**CITY OF ALBUQUERQUE
PLANNING DEPARTMENT
February 25, 2015
DRB Comments**

PROJECT # 1010311 APPLICATION # 15-70065

RE: Tract A, Indian Rest Subdivision

Plat for
Tracts A-1 and A-2, Block 2
Indian Rest Subdivision

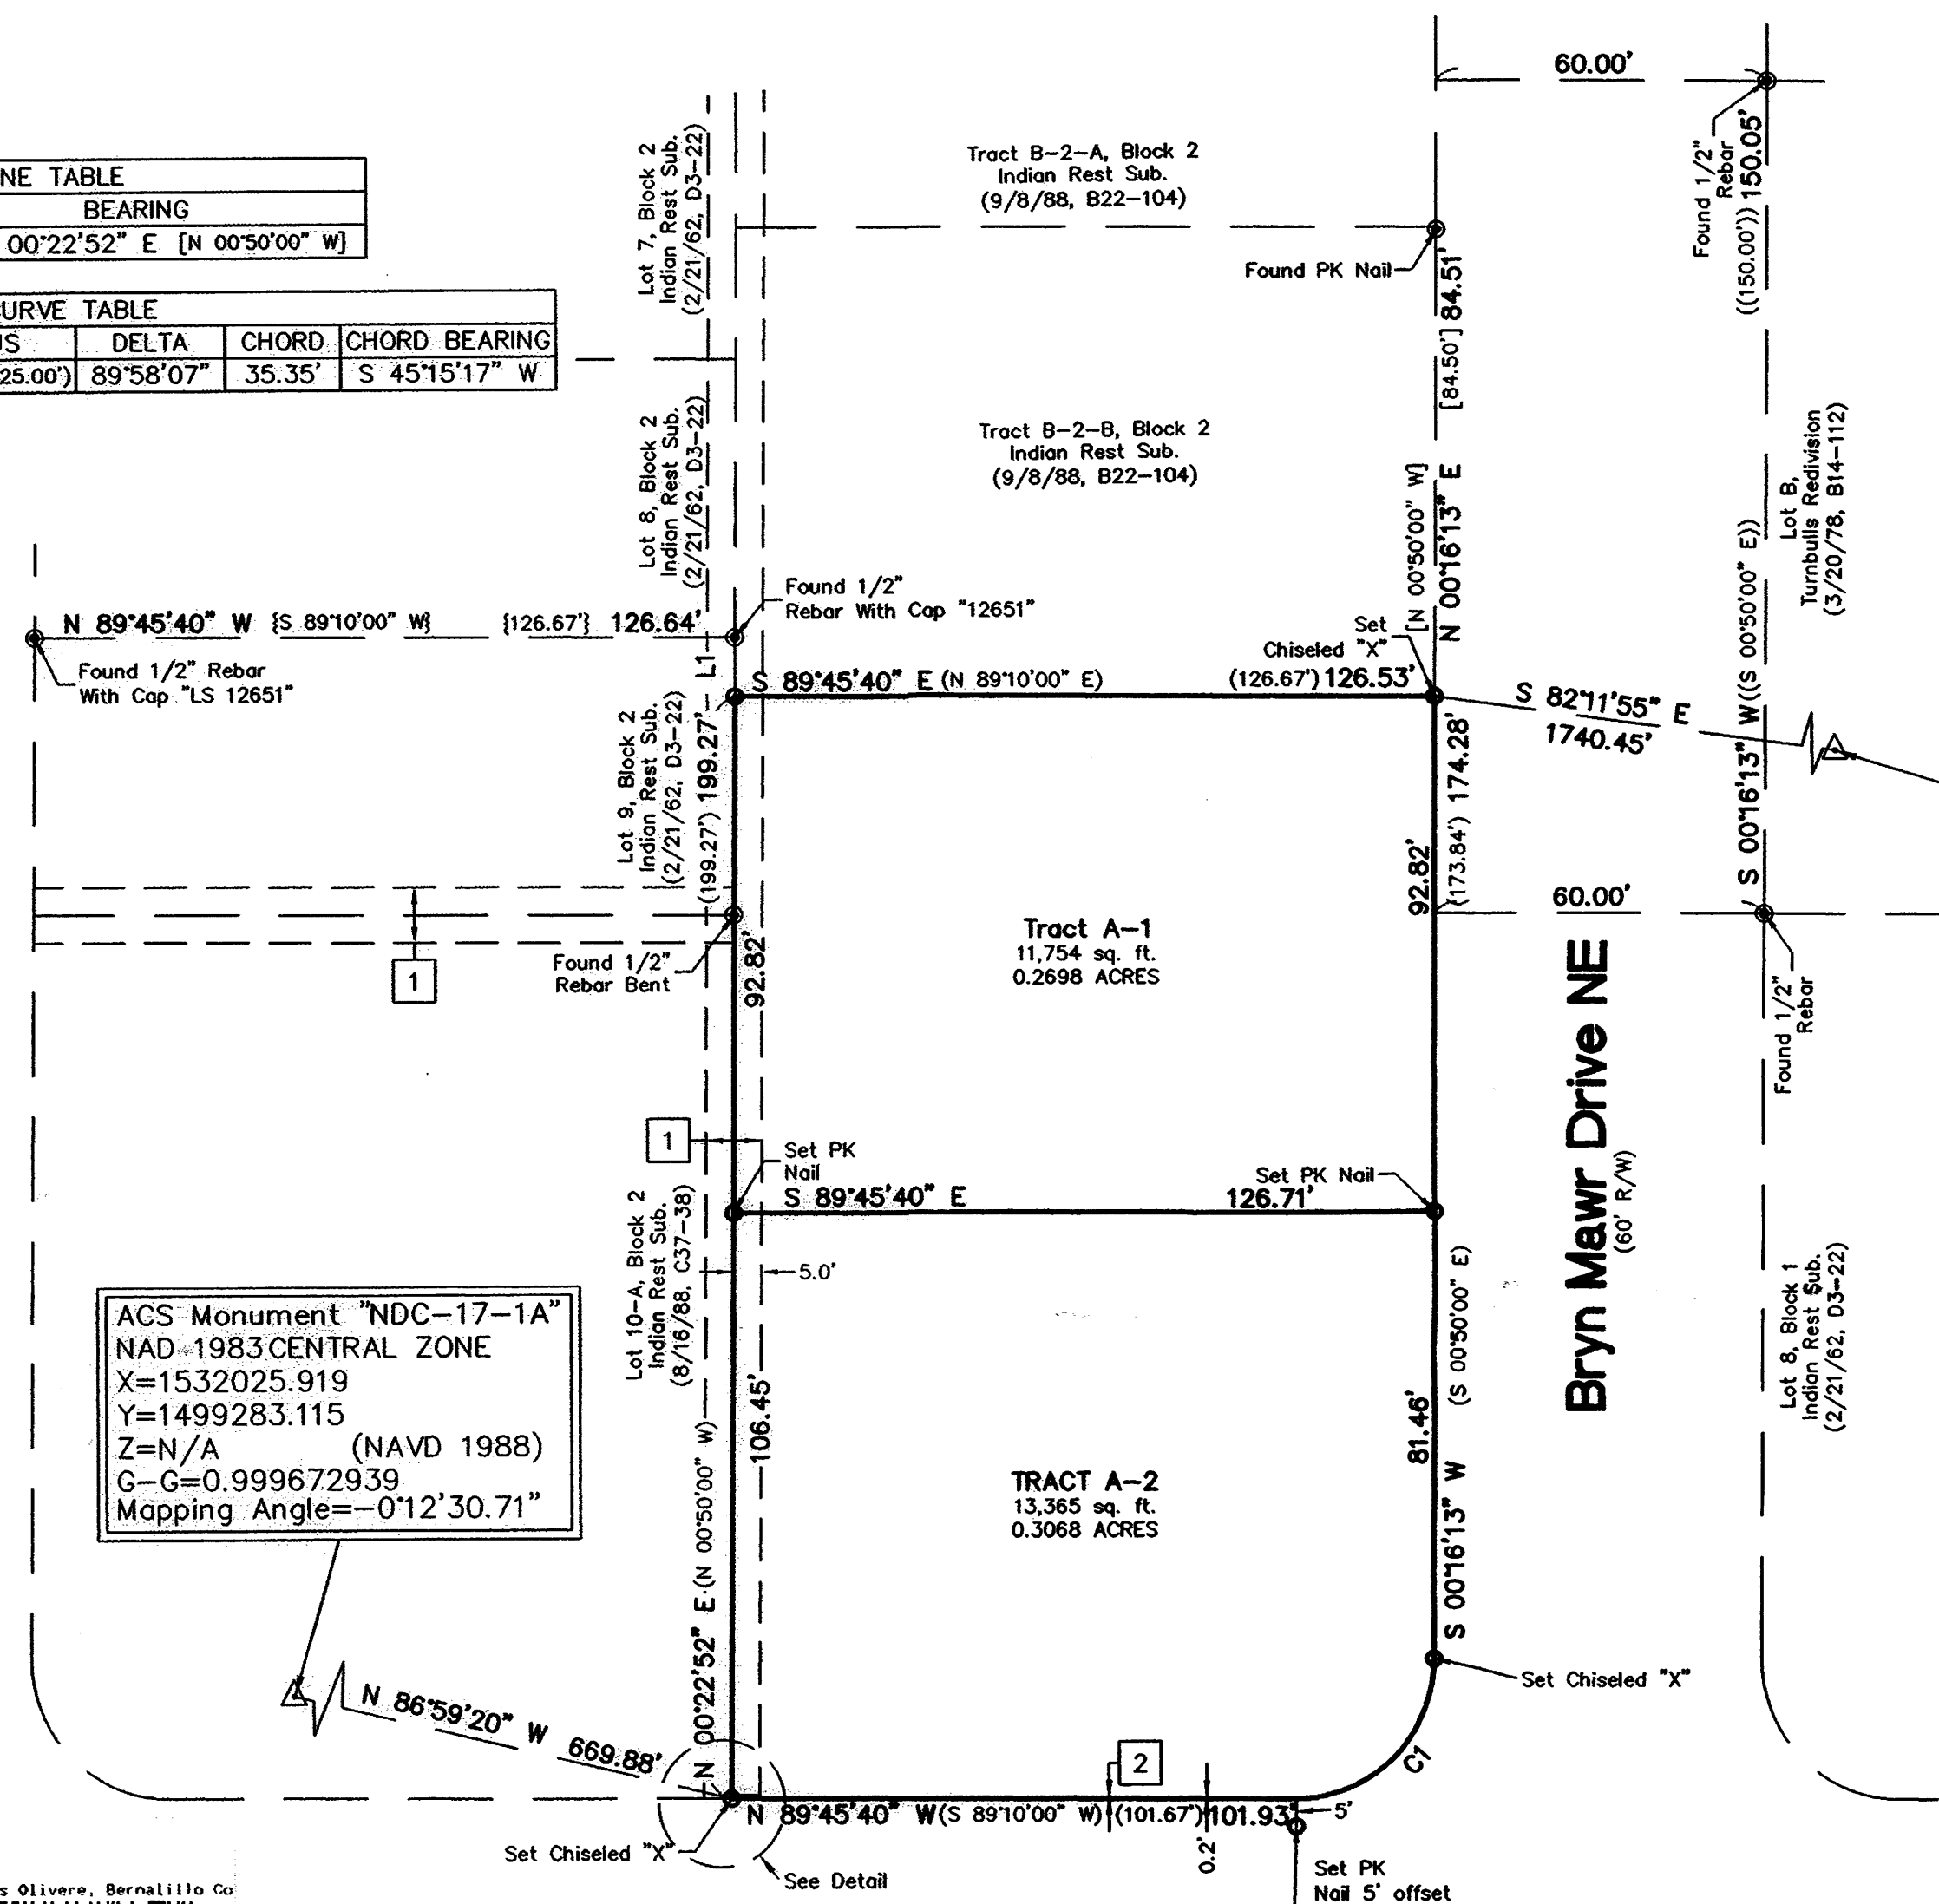
Parking calculations (required and provided) are needed to determine if on-site parking requirements can be met with proposed subdivision; it appears variances would be required for both proposed lots in order for the subdivision to proceed.

If variances were approved, copies are needed for this platting file.
